# MONA OFFSHORE WIND PROJECT

## Response to Hearing Action Points

Application Reference: EN010137

Document Reference: S\_D1\_5

Drawing Number:
Sheet 2

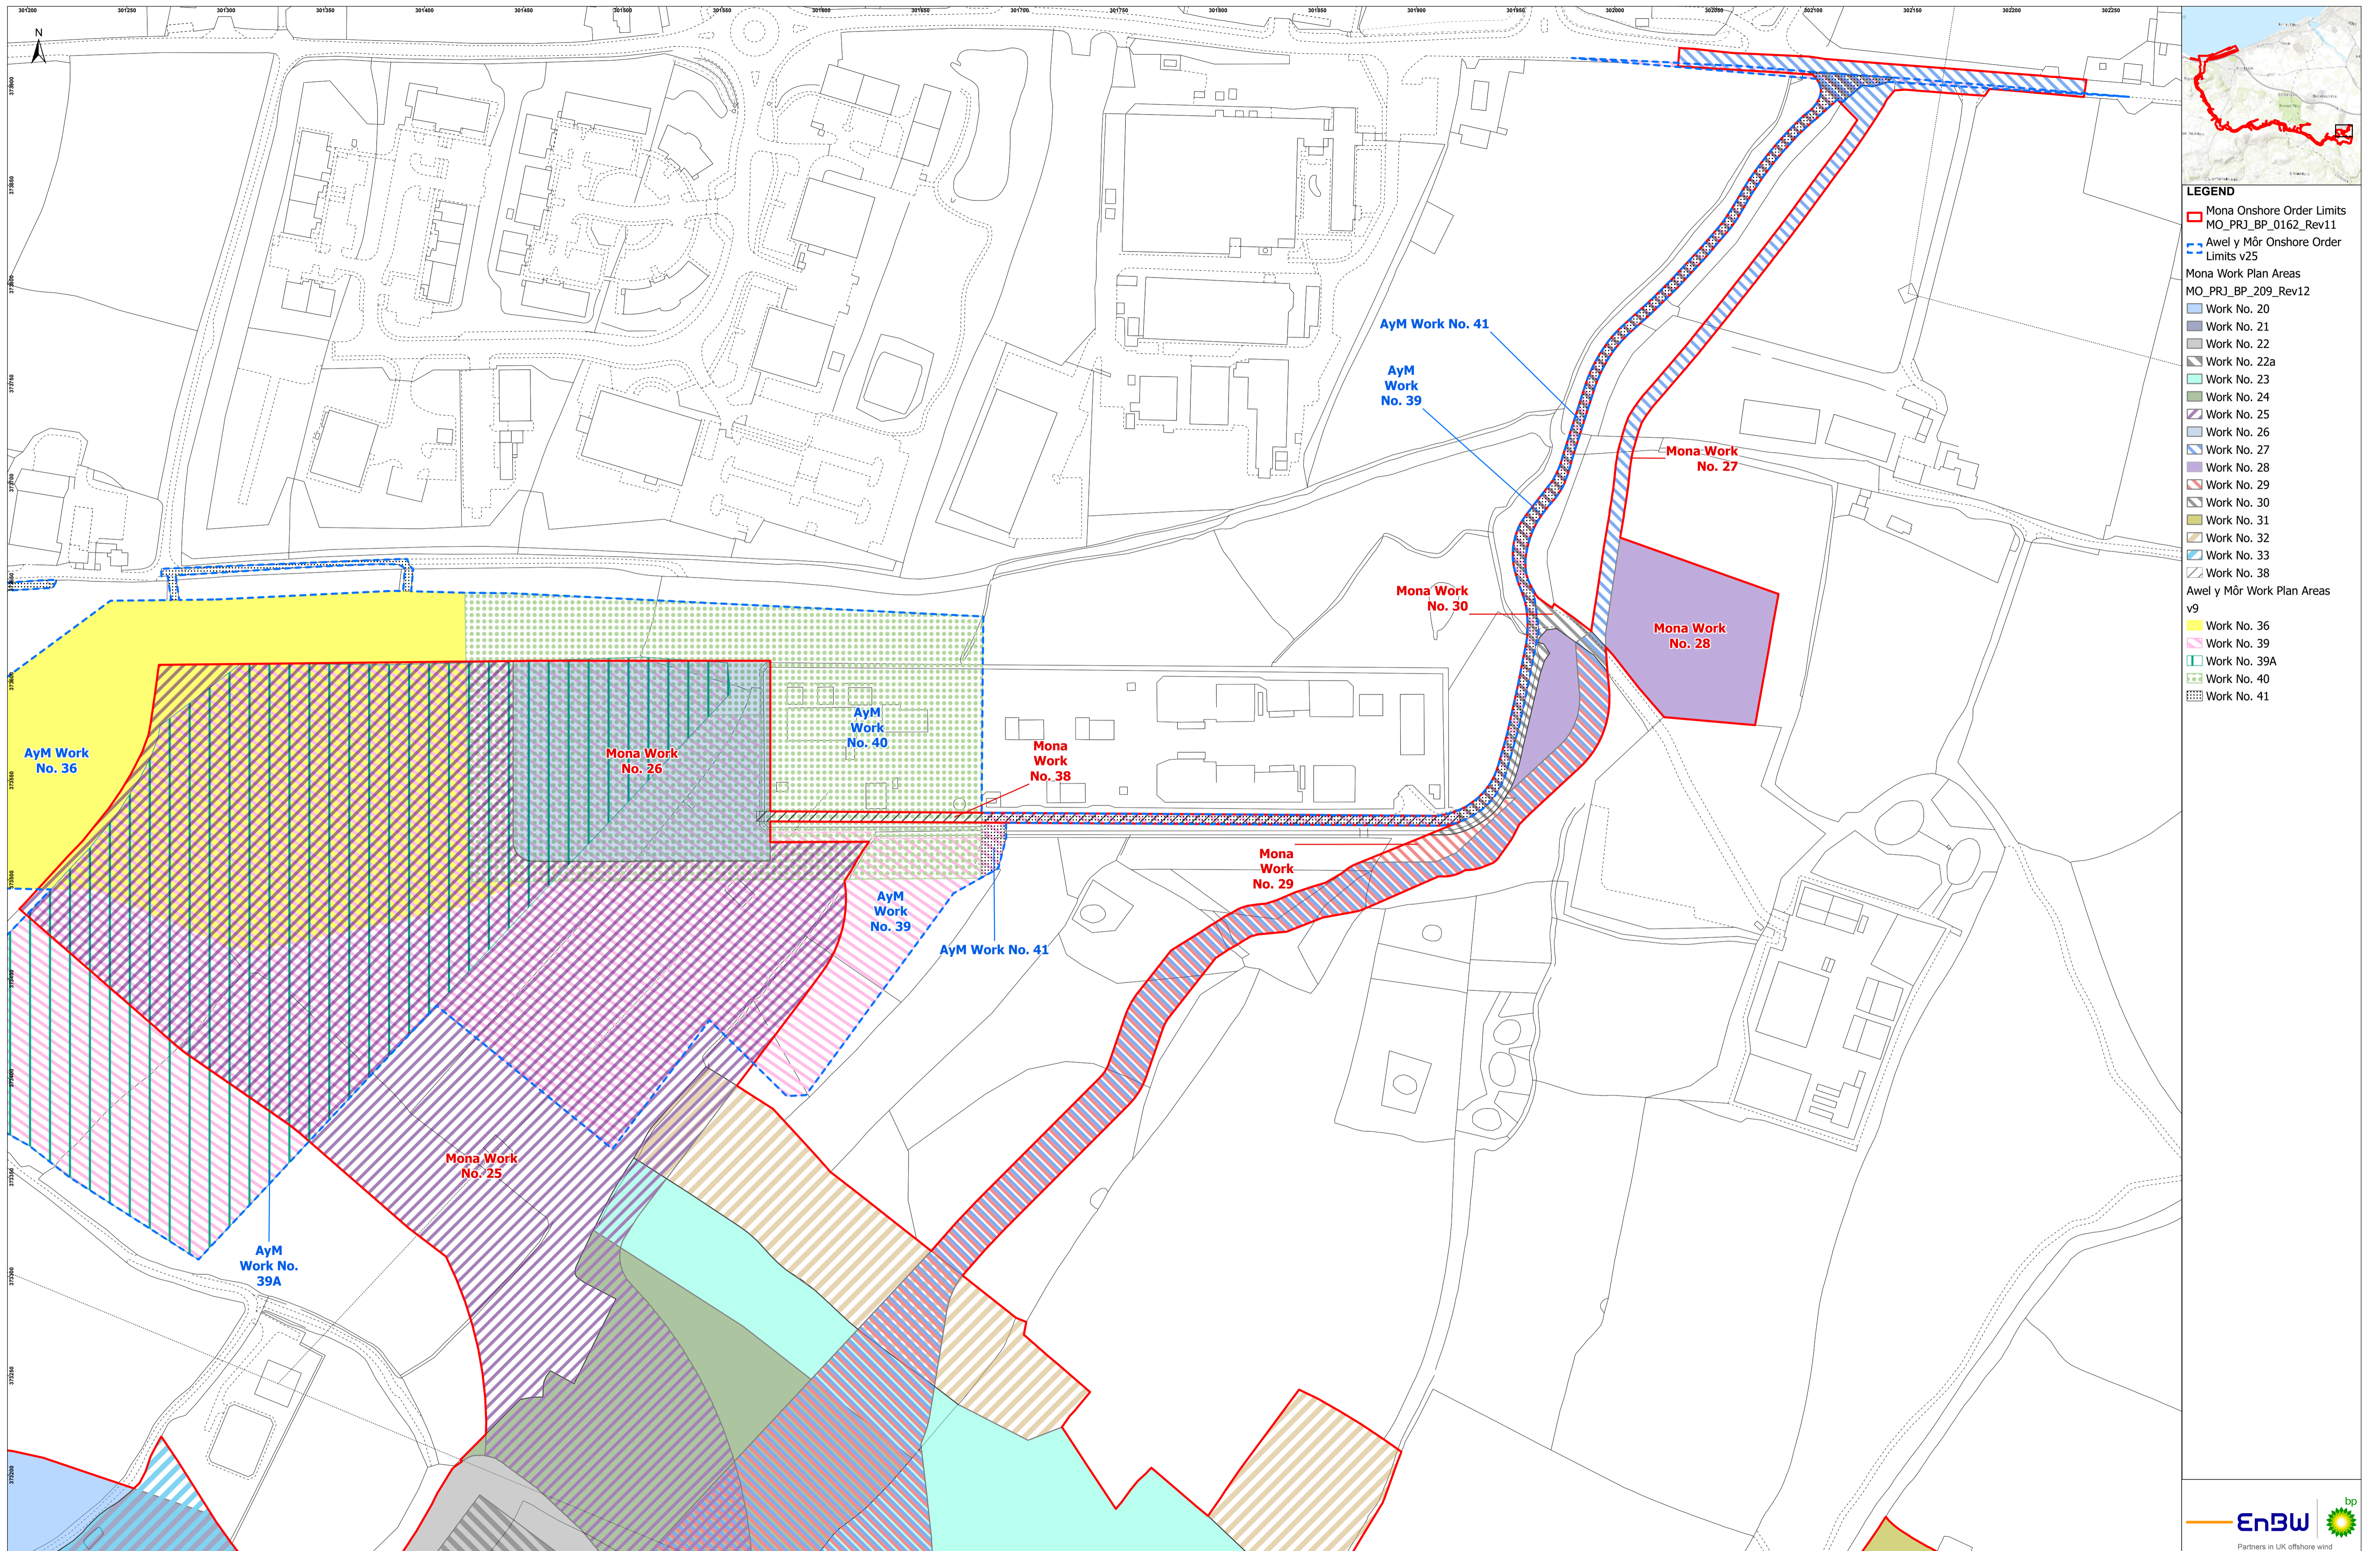
Ref.	Directed to	Action	Applicant's response
			<p>The last row of the table entitled 'Total vehicle movement requirements (Substation) – Mona Offshore Wind Farm' contained within Appendix A of Volume 7, Annex 8.5: Construction Vehicle Trip Generation Assumptions (APP-175) also provides a profile of the total two-way movements per day throughout the proposed period of construction of the onshore substation – including move HGV movements and light vehicle movements. This also shows that total movements peak during months 19 to 22 of the onshore substation construction programme.</p>
HAP_ISH2_15	Applicant	Supply overlay plan showing Mona and Awel y Mor Order Limits in area of approved and proposed sub-stations. Update this plan with National Grid Substation planning application	Please see Appendix to Response to Hearing Action Point: Mona Offshore Wind Project and Awel y Môr Offshore Wind Farm Works Plans Overlays S_D1_5.7 submitted at Deadline 1.
